Our Ref: M/50/20/NMA

Non material amendment following the grant of M/32/19/PL to reconfiguration chimney flue forming resulting in one stack & adjustment of fenestration to provide symmetry.

46 Sea Lane Middleton-On-Sea PO22 7RX

Proposed Elevations

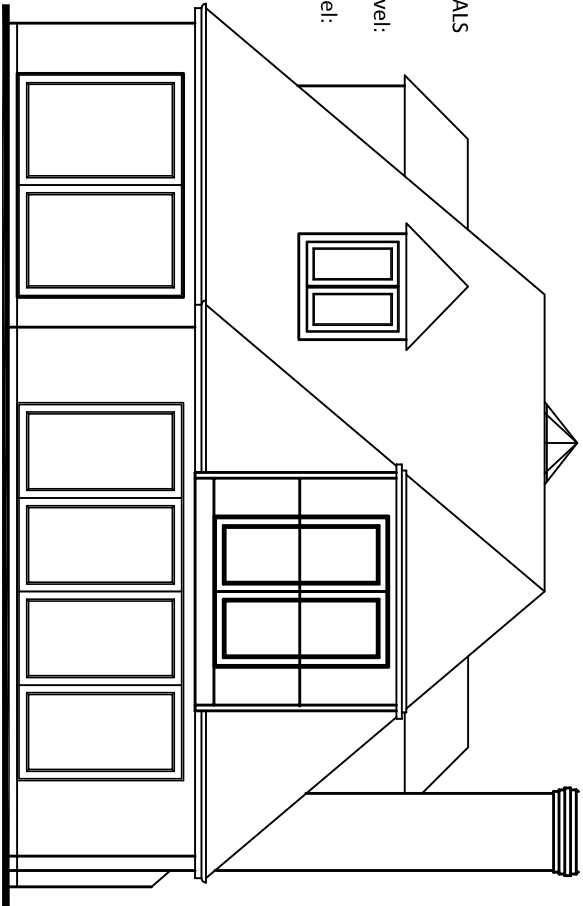
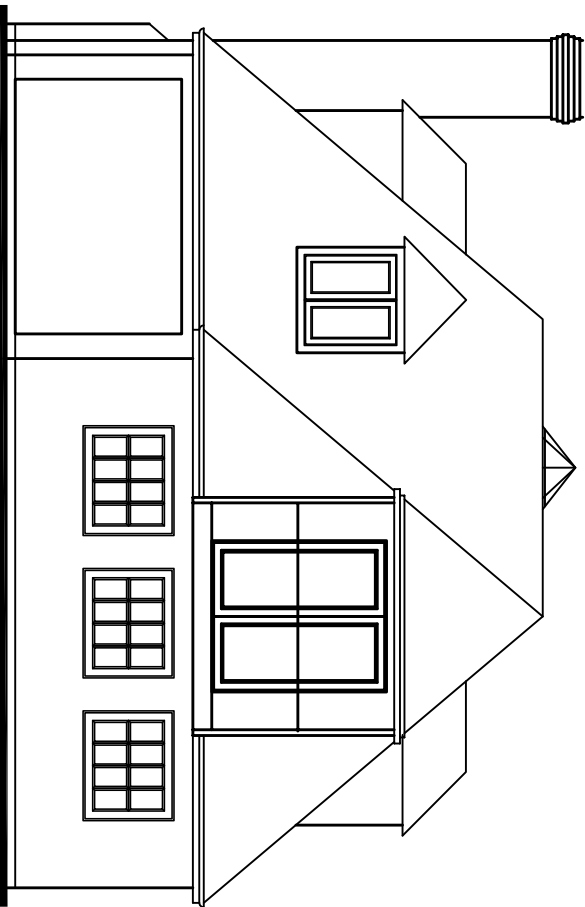
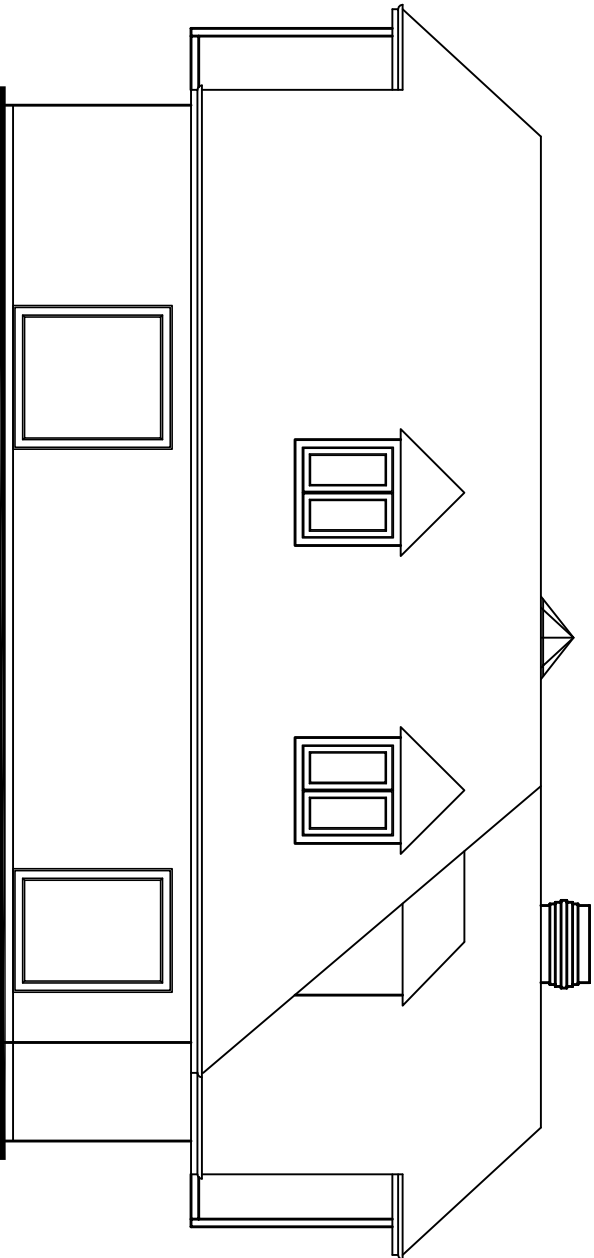
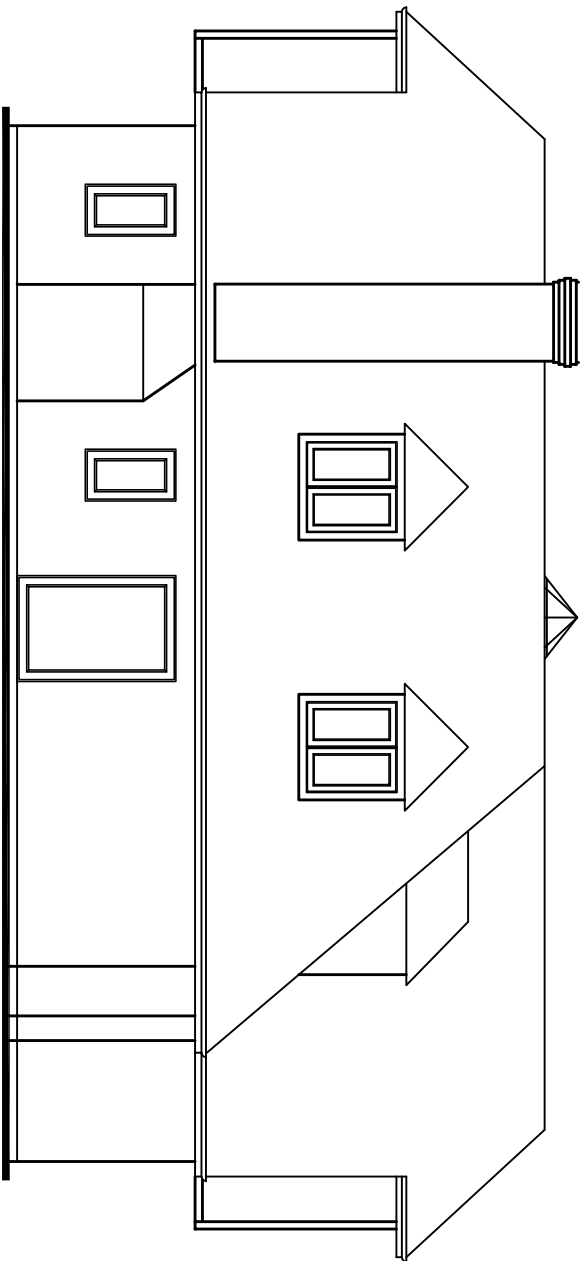
The reasons that these proposals have not been accepted as Non-Material Amendments is because the chimney changes would materially alter the appearance of the approved dwelling and cannot therefore be considered under section 96A of the Town and Country Planning Act 1990.
